Our Reference:
SWS-SUSXW-S106-009499

Date:
21/12/2017

Application to Connect to the Public Sewerage System - Section 106 Water Industry Act 1991. Location: 97 Barnham Road, Barnham, Bognor Regis, West Sussex, PO22 0EQ.

Number
S17-03-01 E

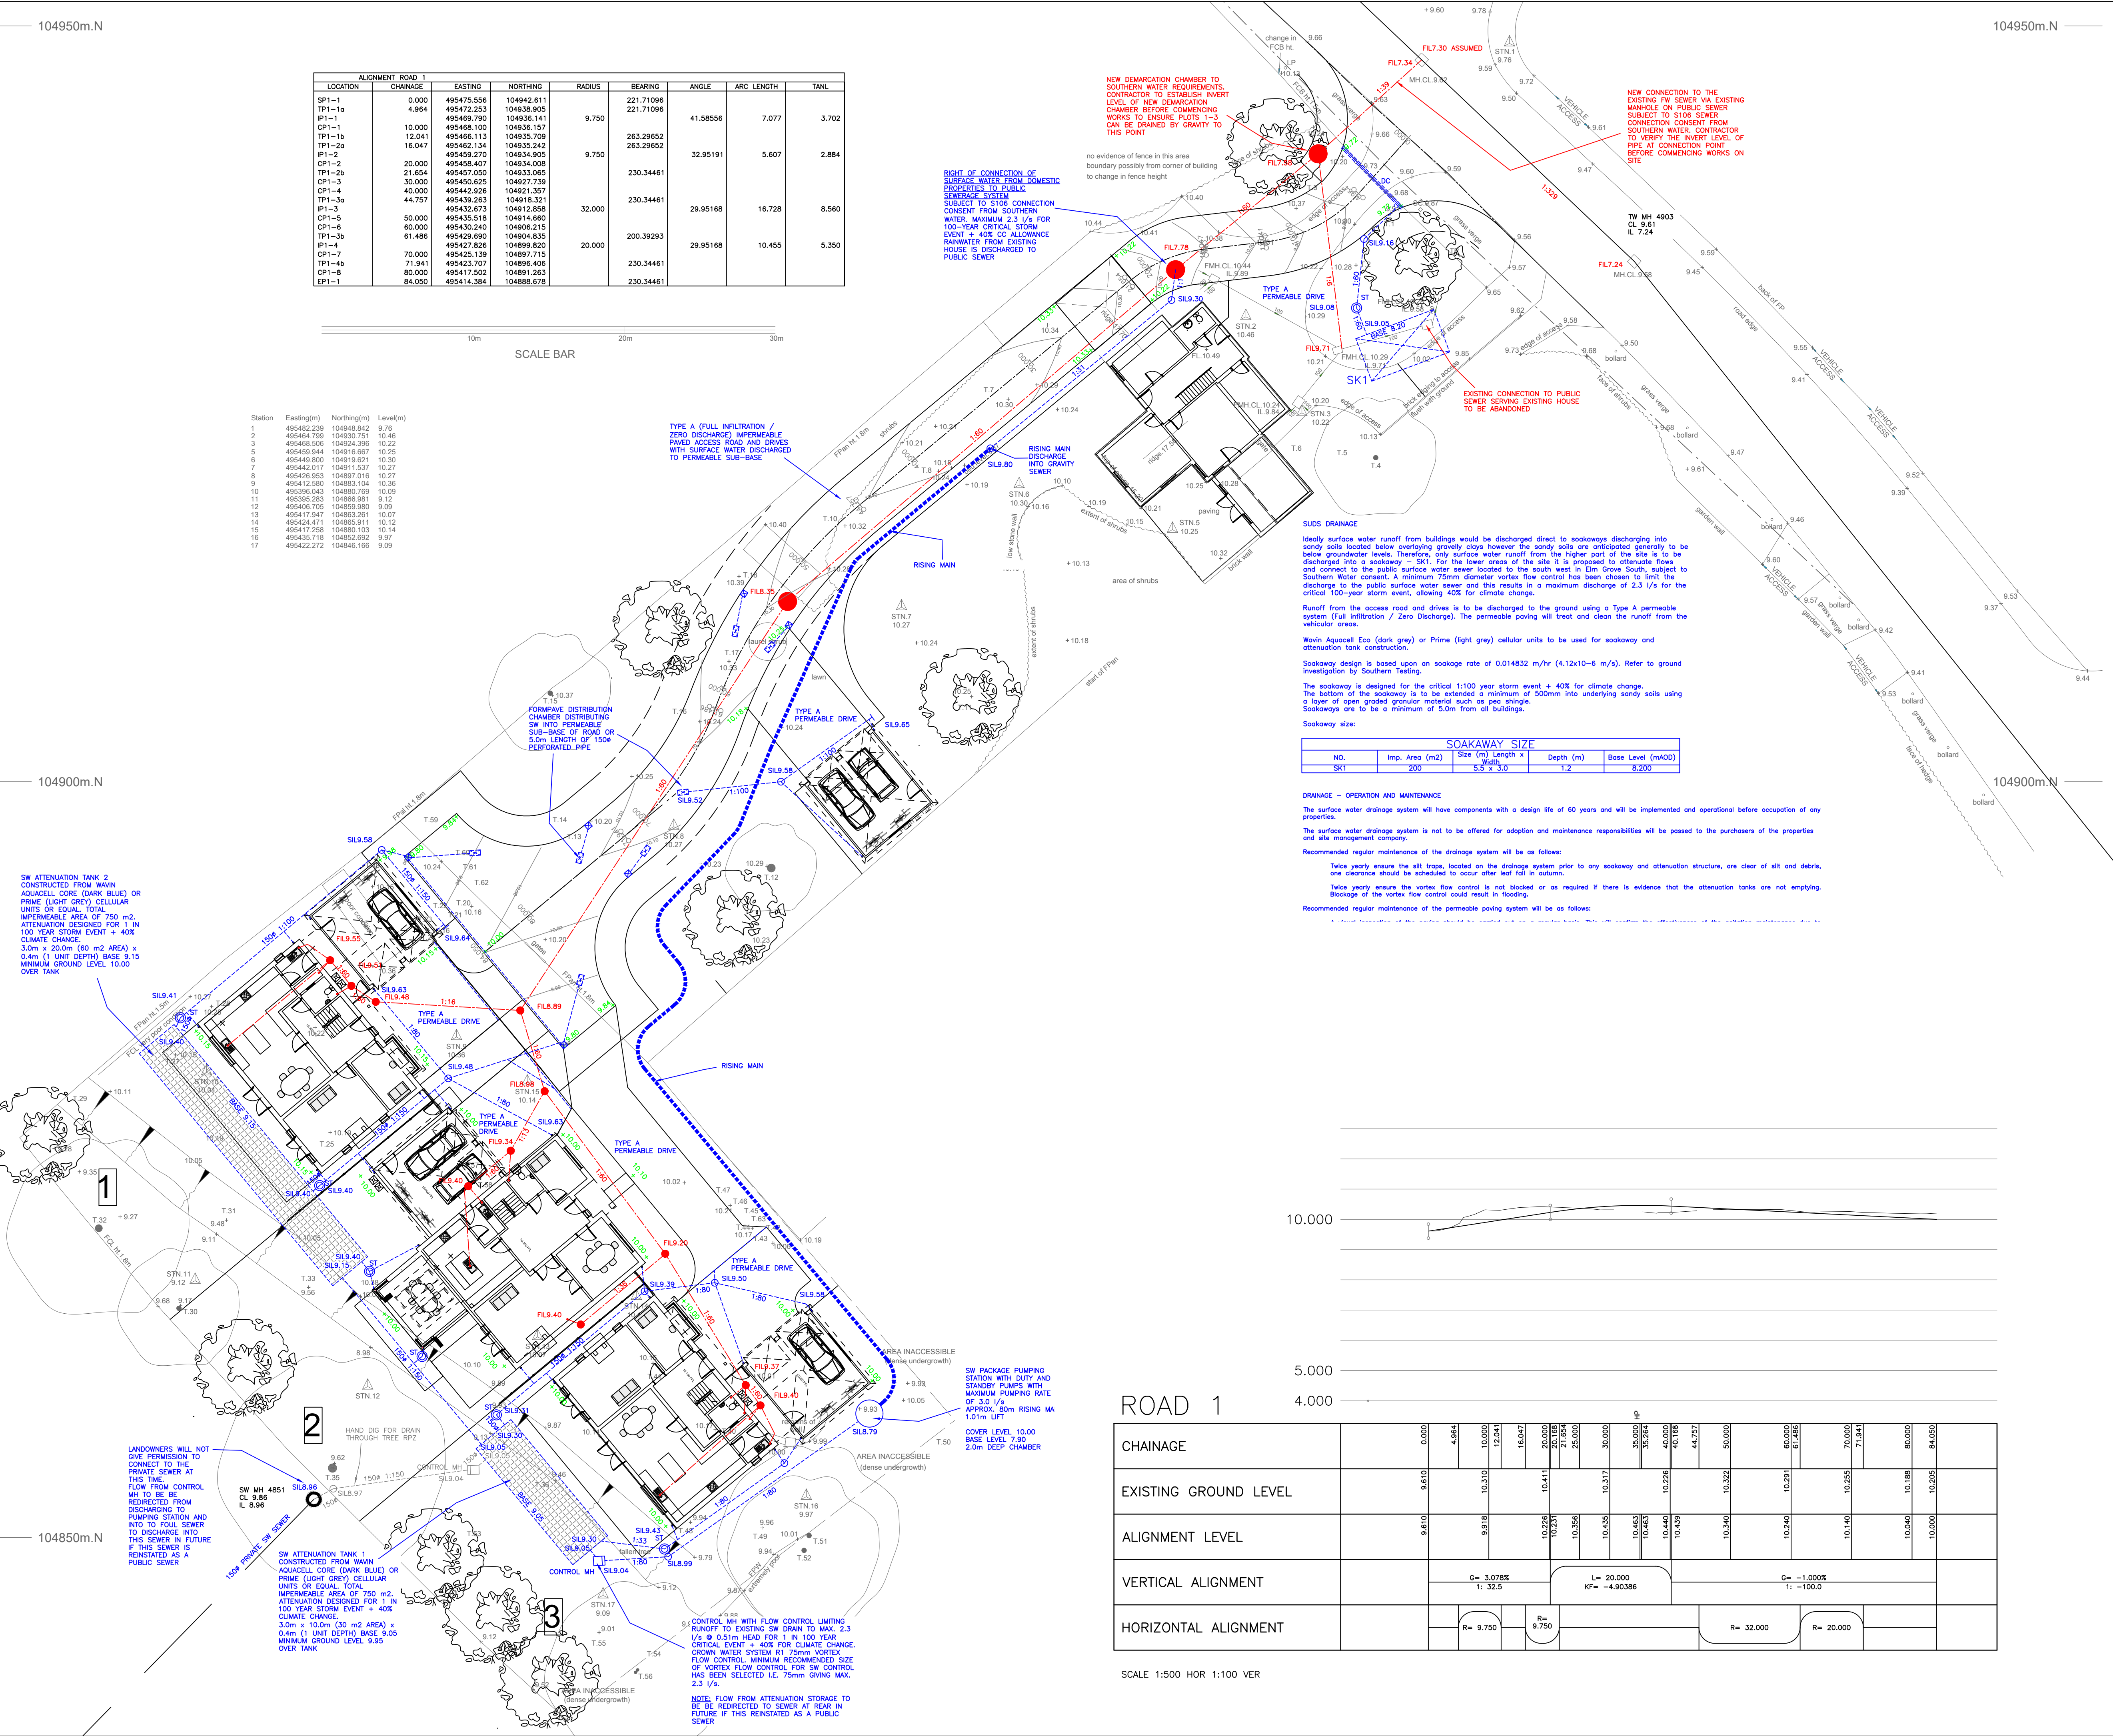
- If the sewer in the land located to the rear is found to be a public apparatus from the ongoing investigation, the connection will have to be redirected to this surface water system. This may require a full Section 98 application to be submitted as this involves third party land and the landowner will be liable for all costs.

- The pumped discharge rate is not to exceed the agreed 2.3 l/s.
